Date: 25 January 2021  
Our ref: 339861  
Your ref: Planning Inspectorate Reference: EN020022

**Planning consultation:** EN020022 AQUIND Interconnector The construction and operation of a 2000 MW subsea and underground High Voltage Direct Current (HVDC) bi-directional electric power transmission link between the south coast of England and Normandy in France.

Thank you for your consultation on the above project with the Examining Authority's (ExA's) further written questions (ExQ2).

Natural England has provided further comments in this submission for Deadline 7. This includes:

Plate 1 - Plots 3-12 and 3-13 as shown on Land Plan as at Application

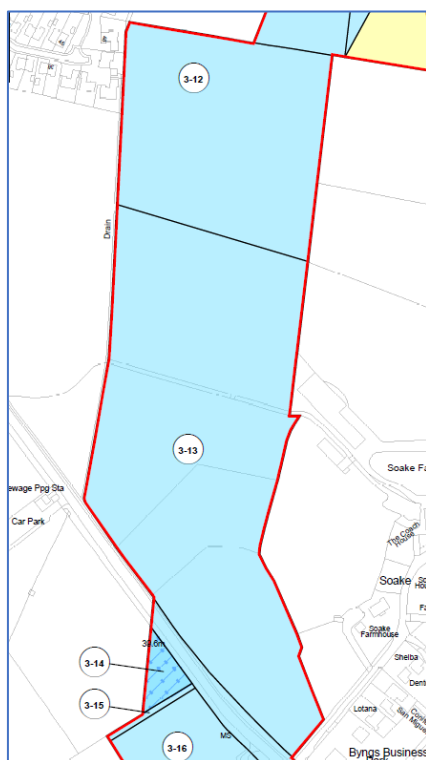
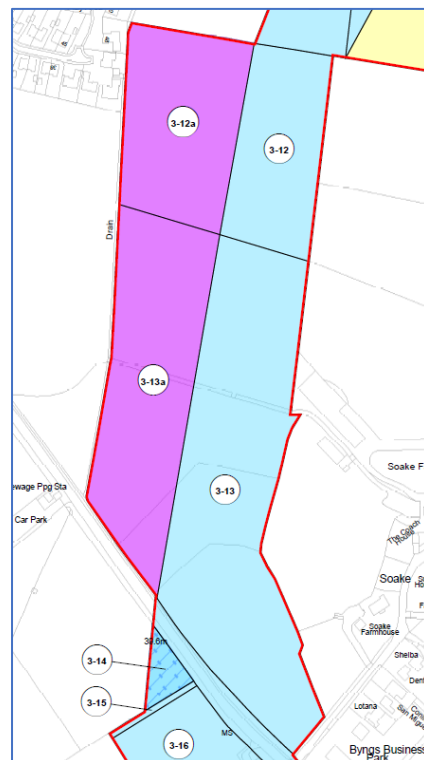
It is noted there is New Access Rights across the Denmead Meadows (3.12a and 3.13a) on REP5-003). It is understood that this is not for vehicle movements, storage or other construction works; but to allow personnel to move between compounds on foot. Provided that this is the case, and this is secured, Natural England raises no further comments.
